KIRKLEES METROPOLITAN COUNCIL INVESTMENT & REGENERATION SERVICE

DELEGATED DECISION FOR DISCHARGE OF CONDITION - NOTIFICATION OF AGRICULTURAL DEVELOPMENT

Reference no. **2023/N /93717/W**

Description	Prior notification for erection of agricultural building
--------------------	---

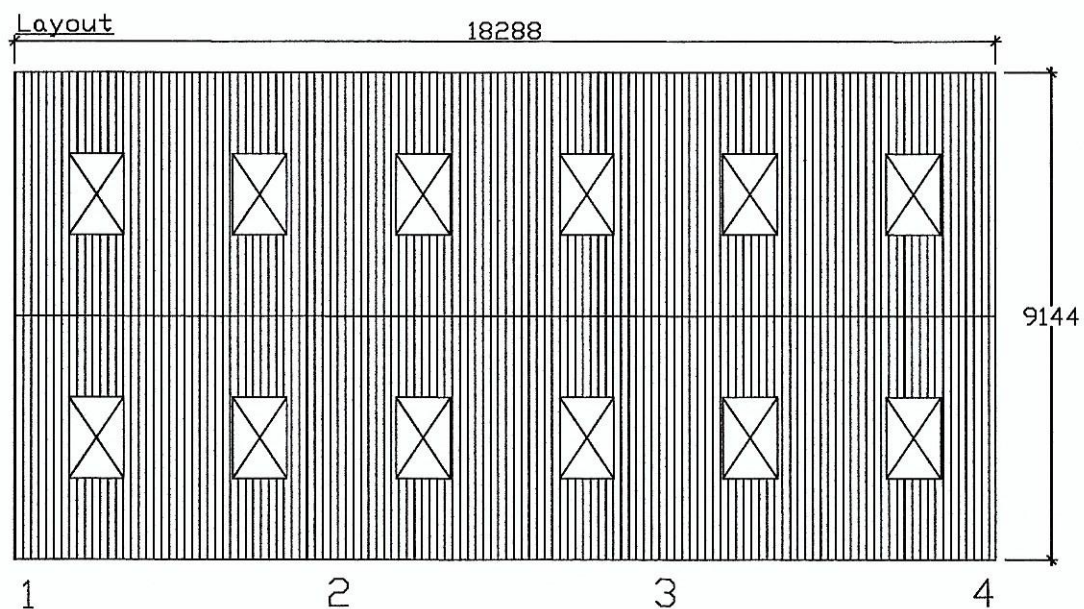
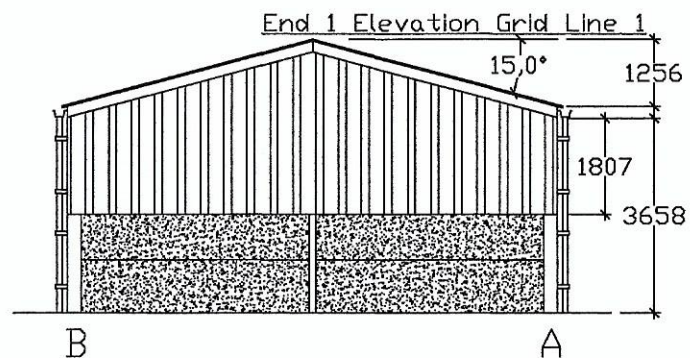
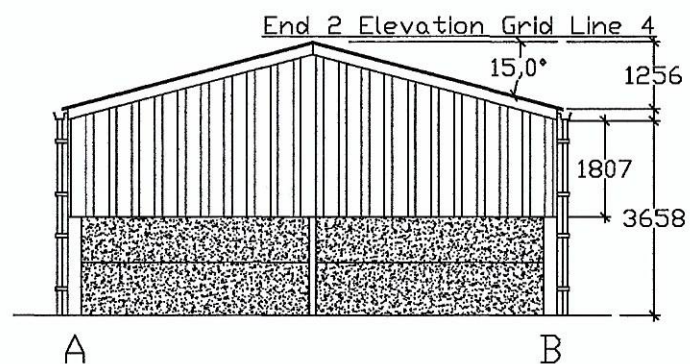
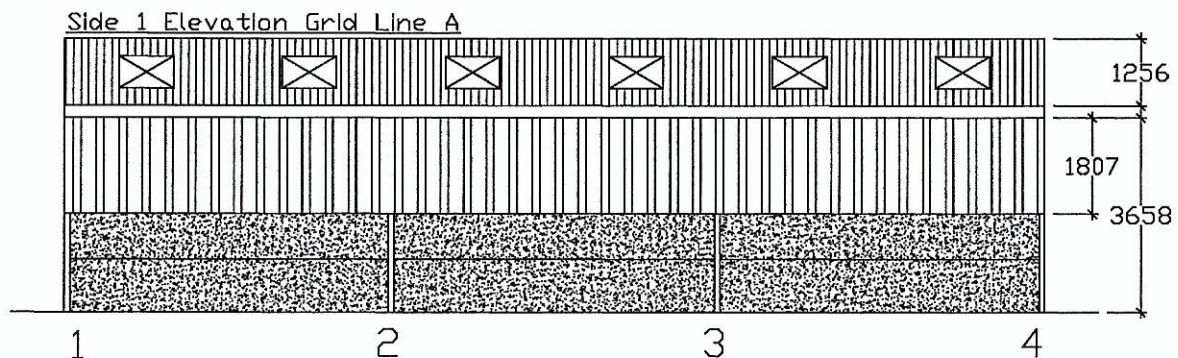
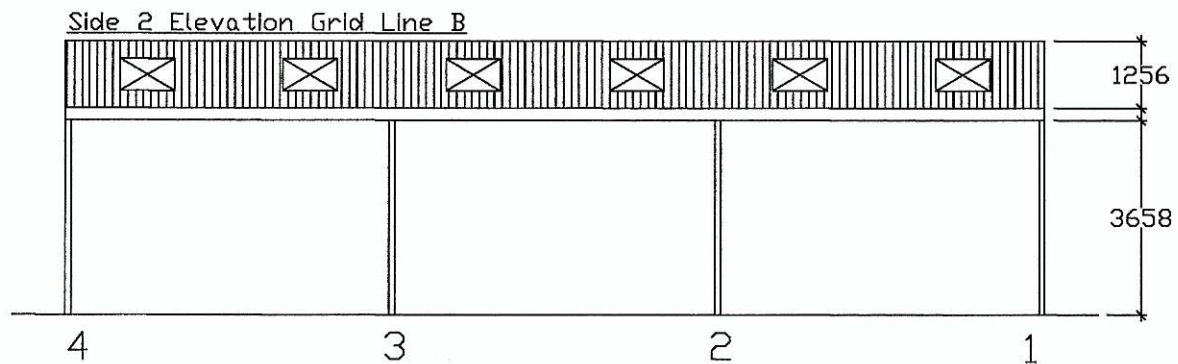
The building would be constructed from grey pre-stressed concrete panels on the lower half of the structure and treated Yorkshire timber boarding on the upper half, with green box profiled sheeting to the roof. The building is to be of a simple utilitarian design, would have a rectangular footprint and would benefit from a pitched roof design. The structure would have an eaves height of 3.6m, rising to an overall height of 4.8m to the ridge line, this is likely provided to allow enough headroom for the storage of machinery. For these reasons, the design and external appearance of this development are considered appropriate.
